Subject: RE: Saltbox Unit 9 site Planning Condition 12 response Surface water

Paul Cann
Principal Drainage Engineer
Engineering Services

Please see attached revised drainage proposals for the Saltbox Unit 9 project for the release of planning condition 12. The proposals have been amended to lift the drainage system up to achieve a gravity discharge as per the original strategy. We have included on the drainage plan drawing pipe sizes, gradients, cover and invert levels also added to the drawing as requested.

Revision
B

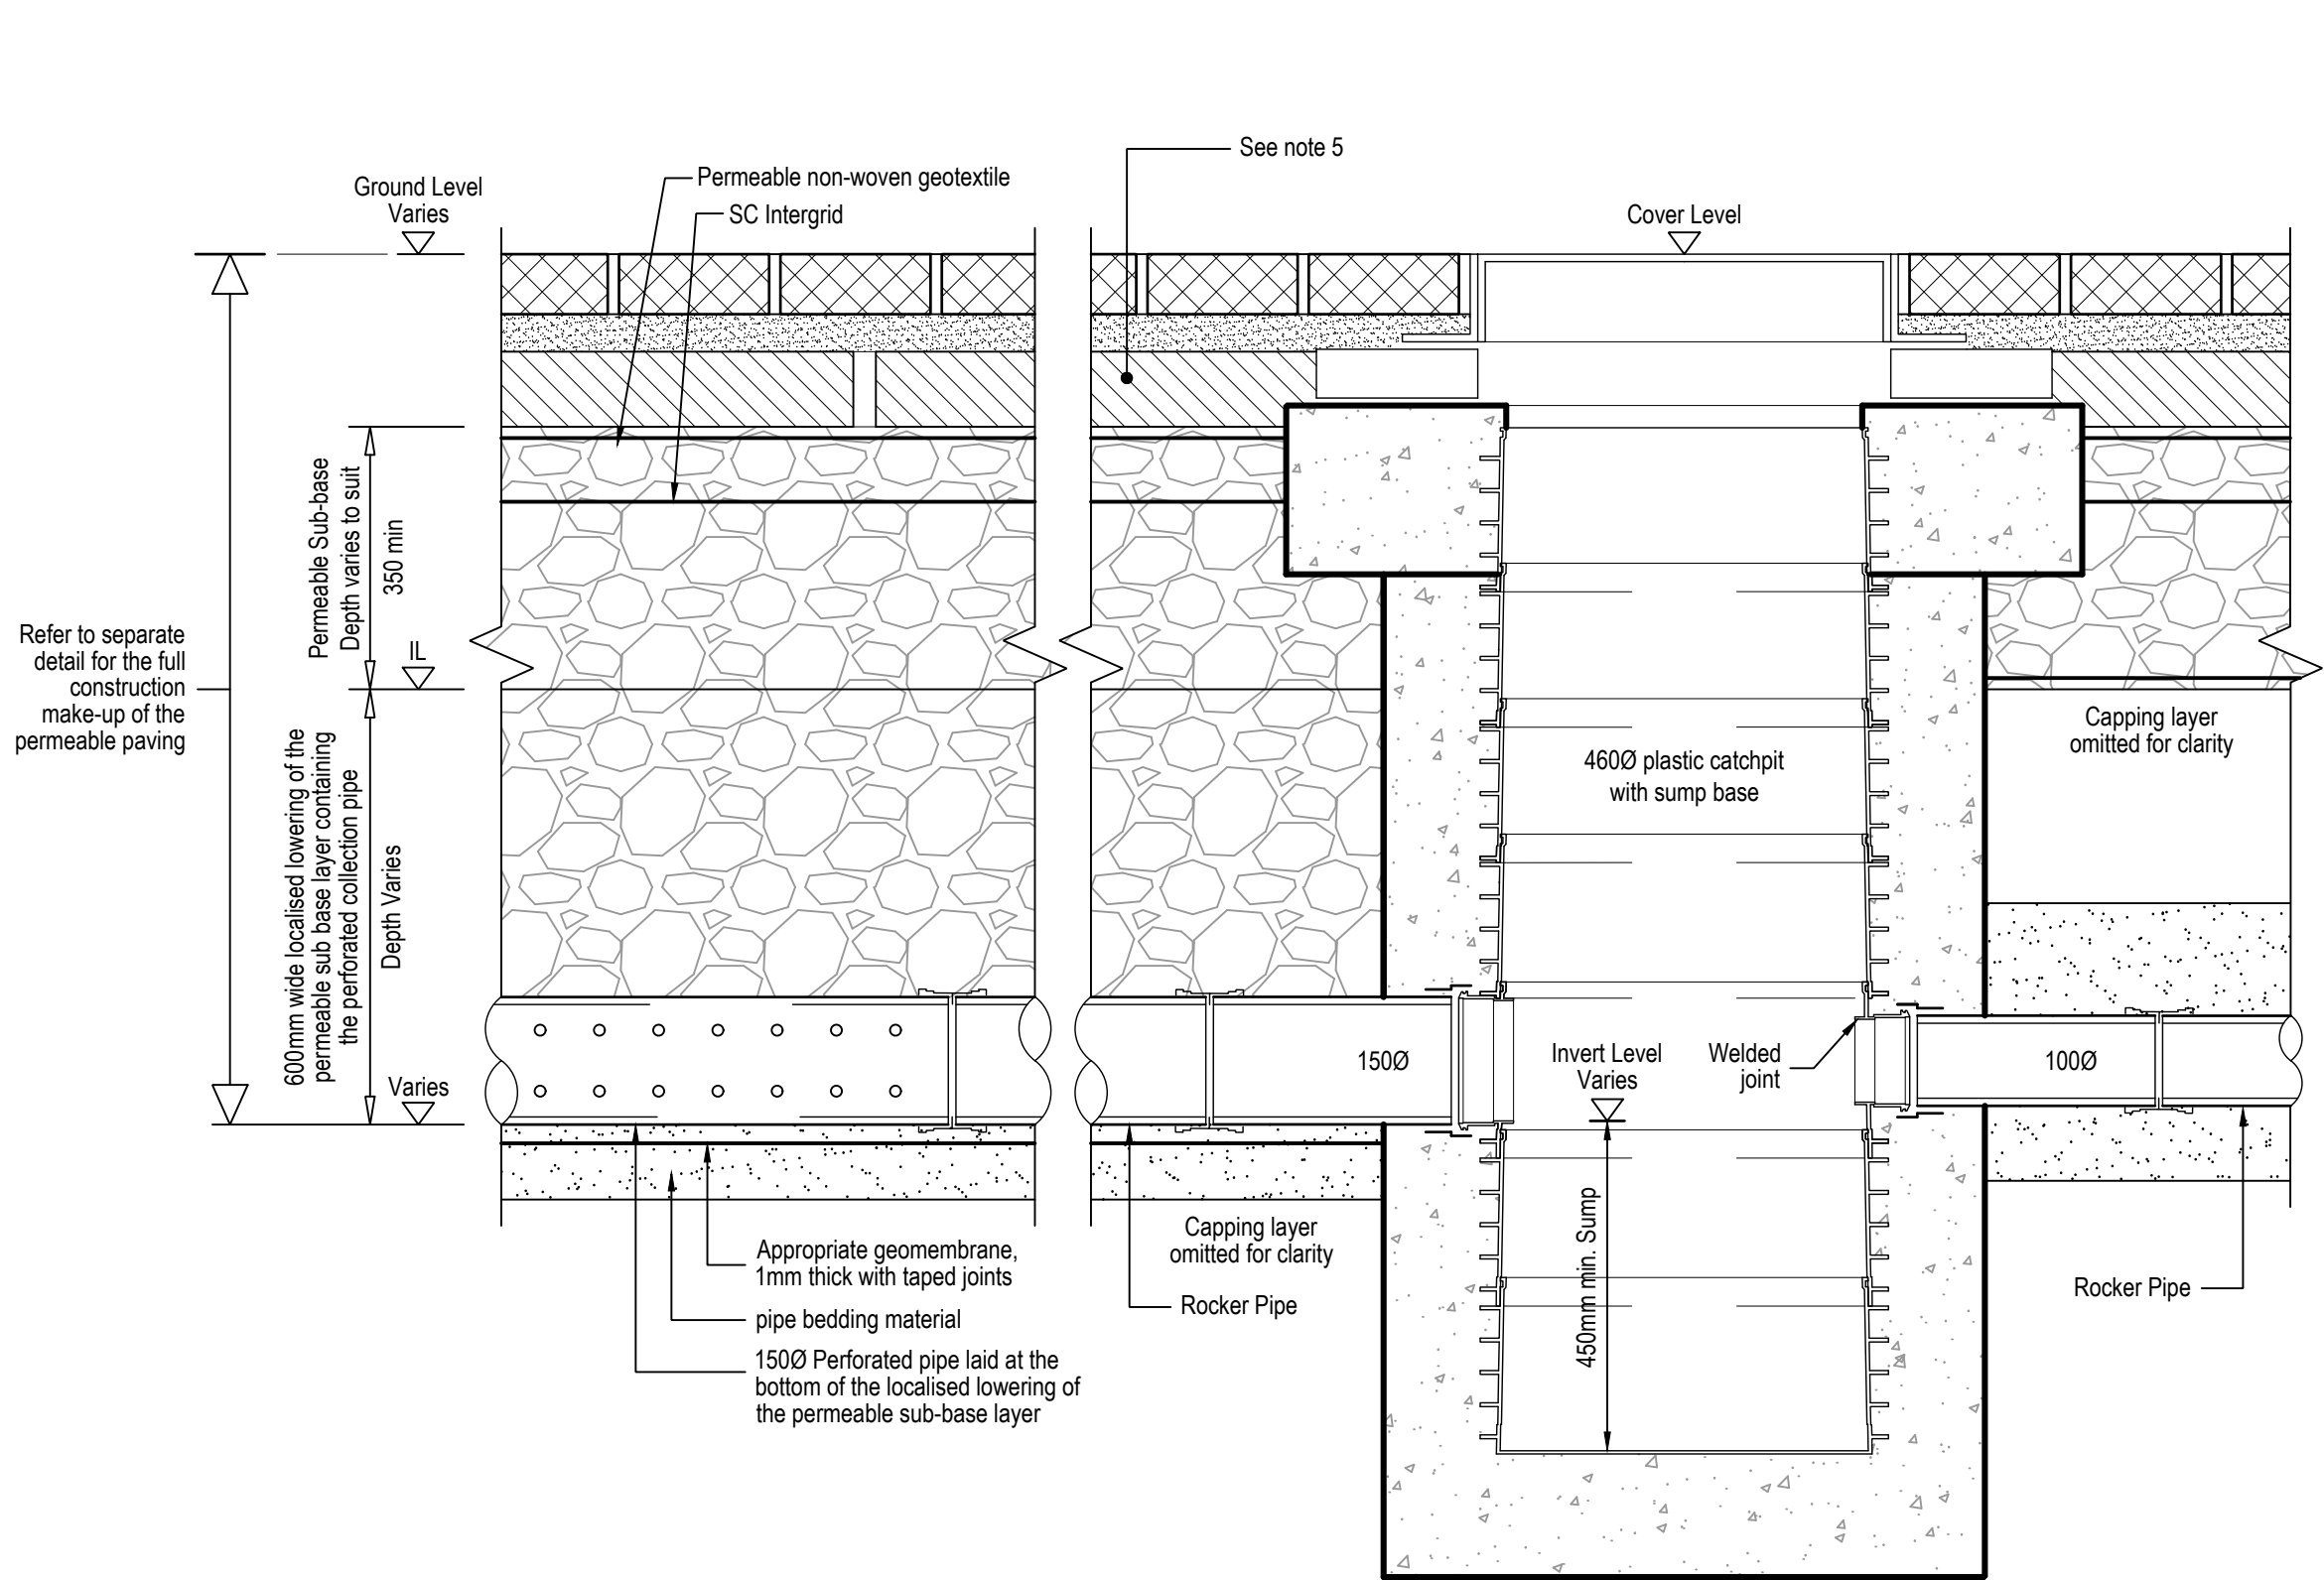
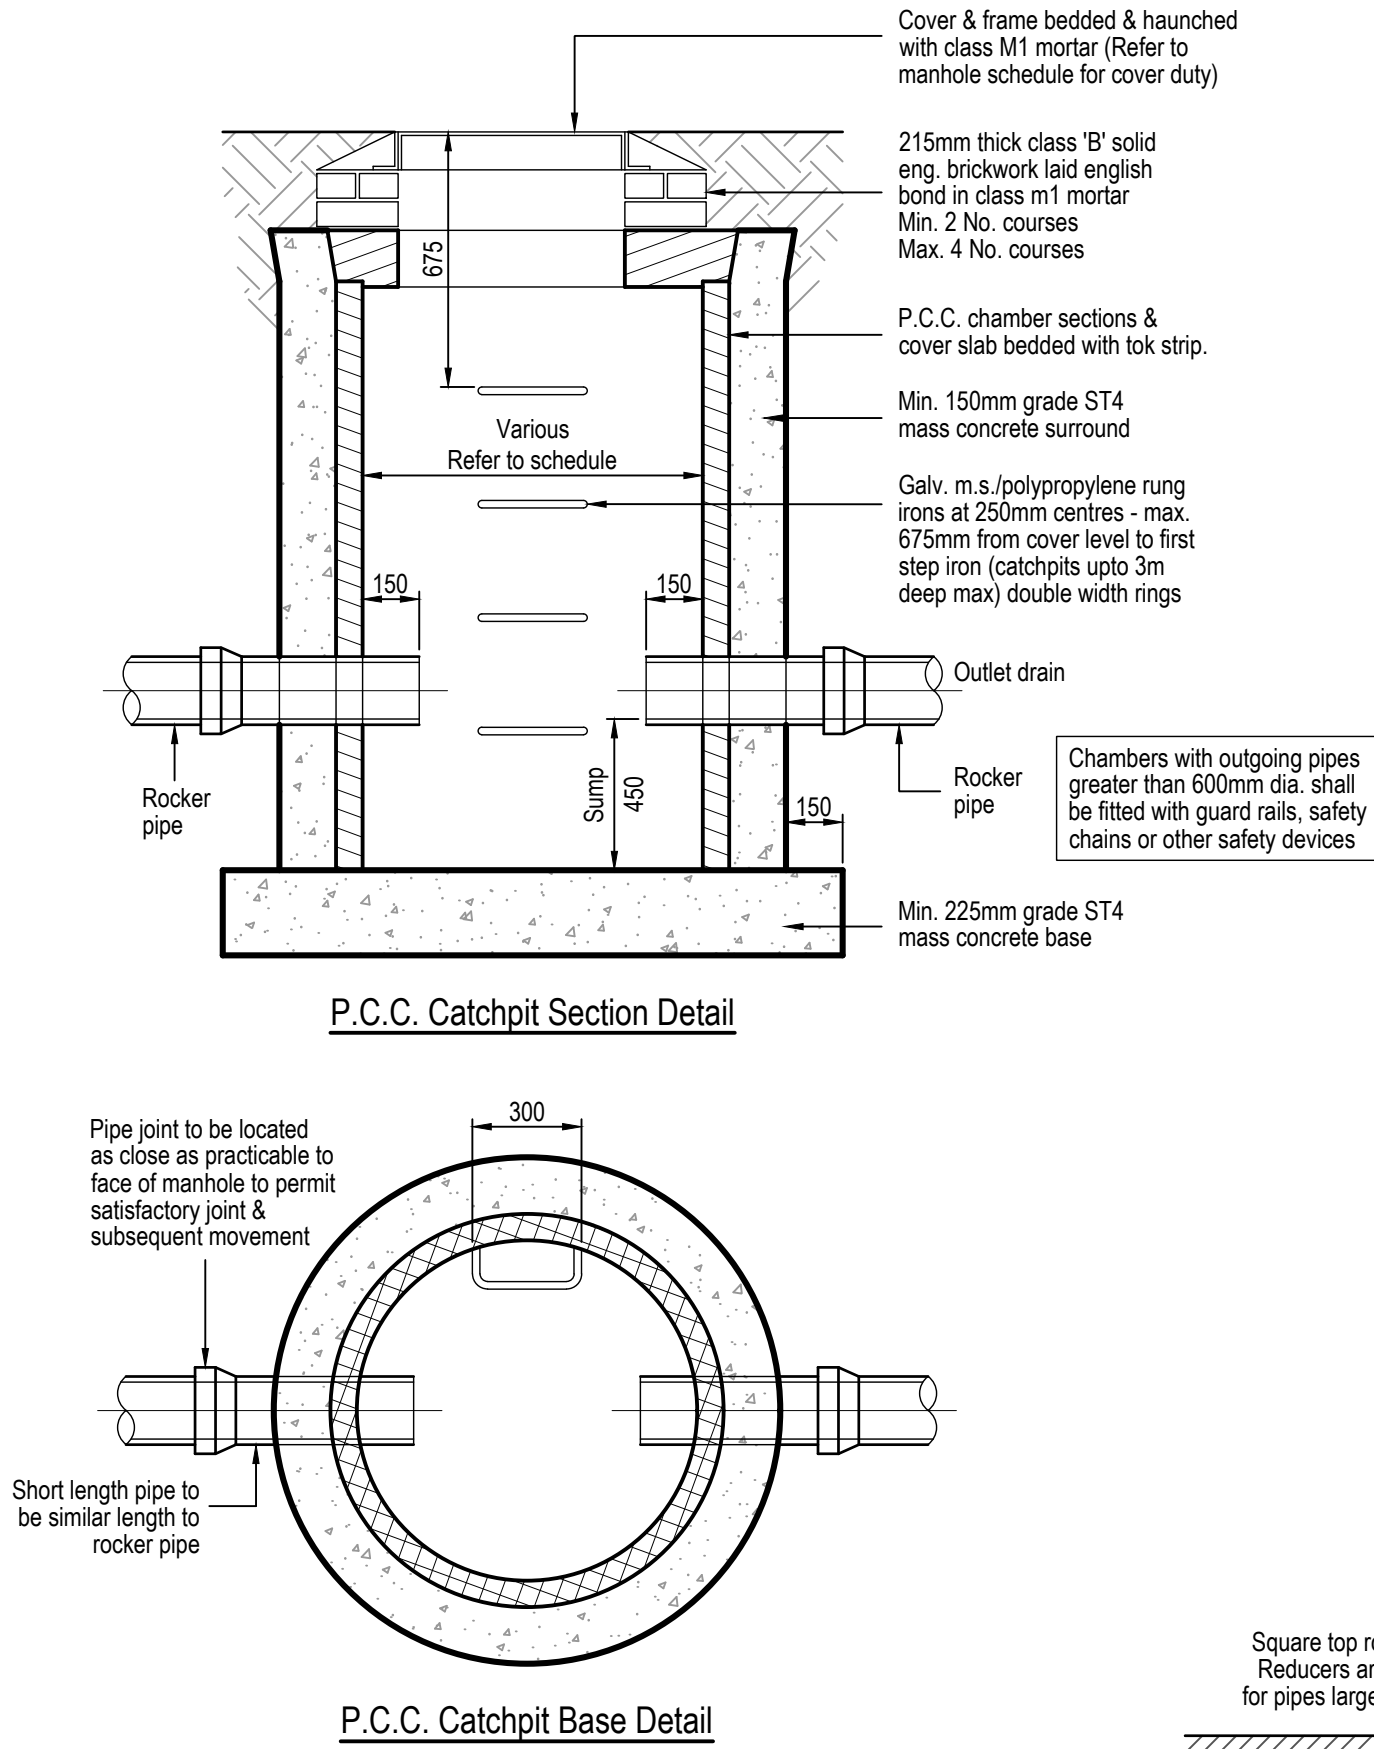
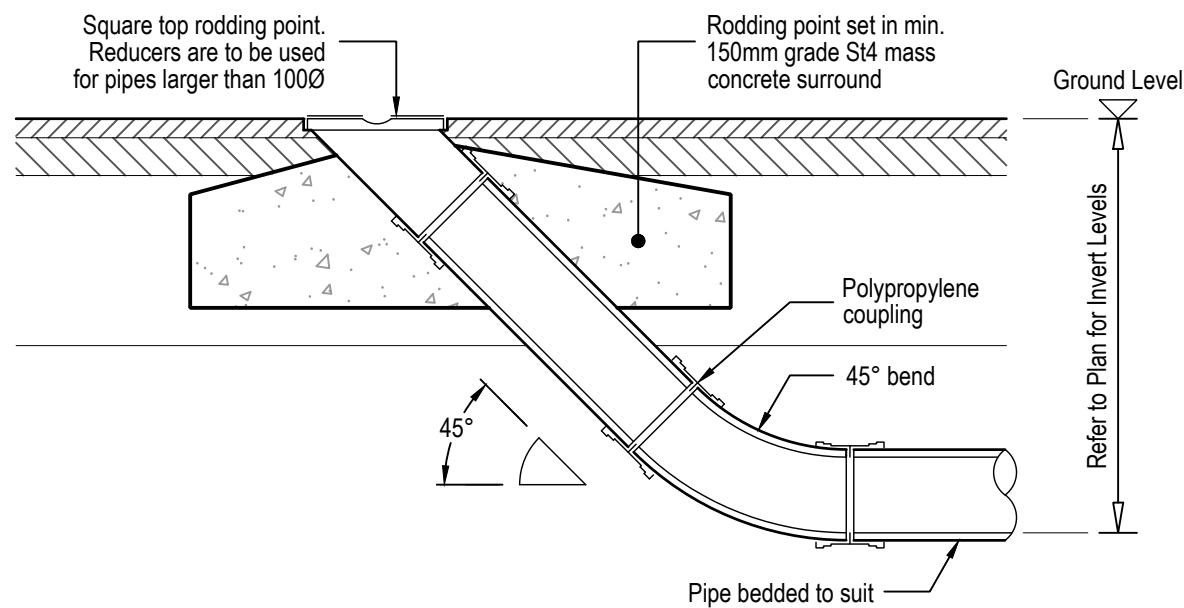
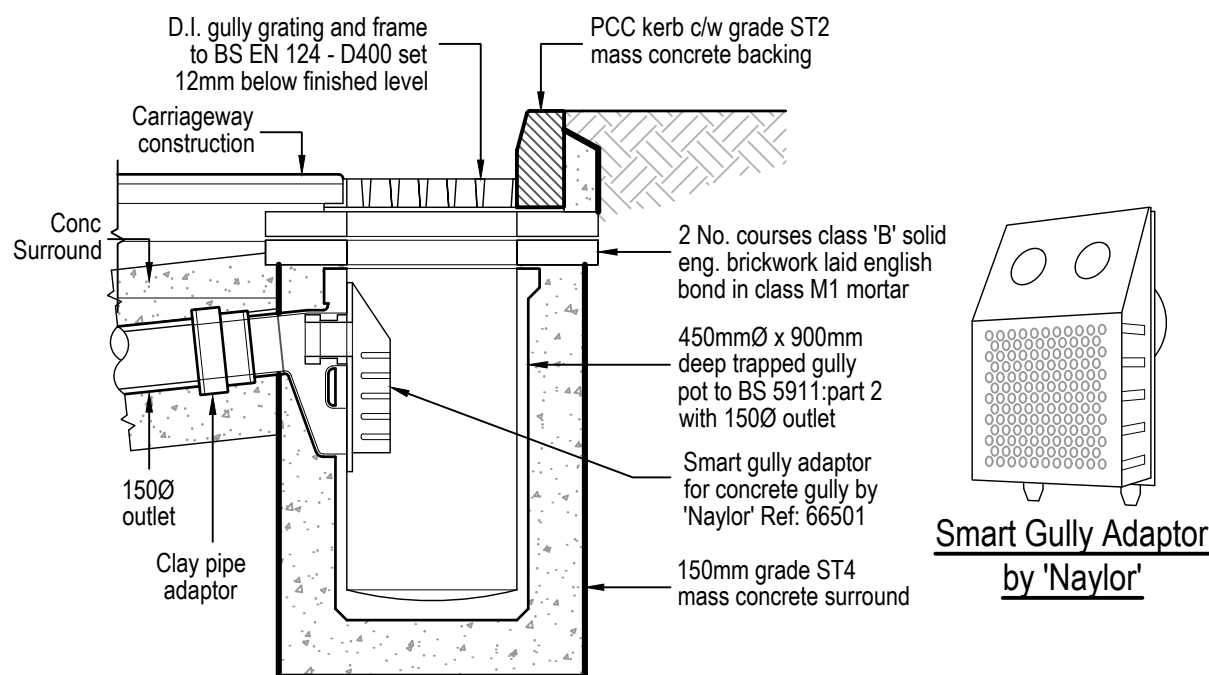
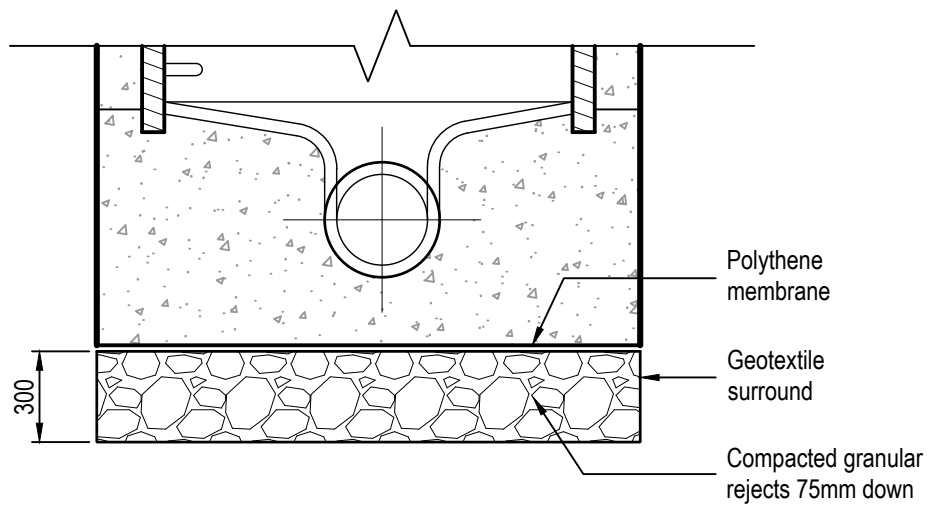
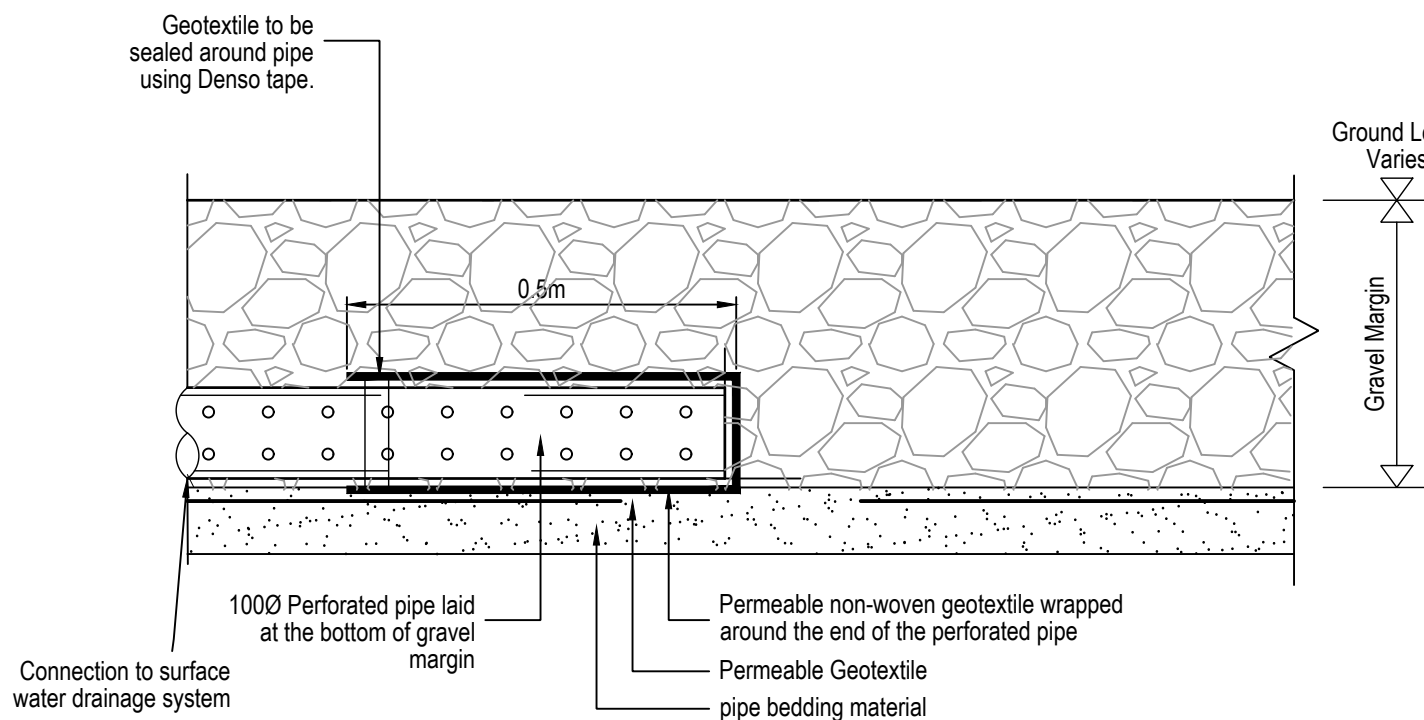
10. **Permeable paving/collection pipe detail – formation level geomembrane to be permeable as opposed impermeable to make use of any possible infiltration, no matter how minimal.** As per Pauls previous comments, we would have concerns regarding the entry of groundwater into the surface water drainage system. Our design does not have the spare capacity to accommodate any potential groundwater entry. I certainly wouldn't want groundwater entering the system either. On previous phases, permeable paving formation levels were set above peak recorded groundwater levels. Please confirm the recorded groundwater levels at these locations so it can be discussed further. Please see email from Paul regarding groundwater levels and further reasoning for tanking of permeable paving. ok

26. Provide fully detailed road gully construction details including pipe diameter.
27. Provide hydrobrake technical details data sheet from the manufacturer.

30. Bypass separator – specify class D400 cover/frame. Please confirm that the separator can accommodate 375mm diameter outgoing and incoming pipes.
31. Provide construction detail for rodding eyes.

32. PCC ring catchpits; Specify min; 450mm sump.
33. Permeable paving/collection pipe detail – formation level geomembrane to be permeable as opposed impermeable to make use of any possible infiltration, no matter how minimal.
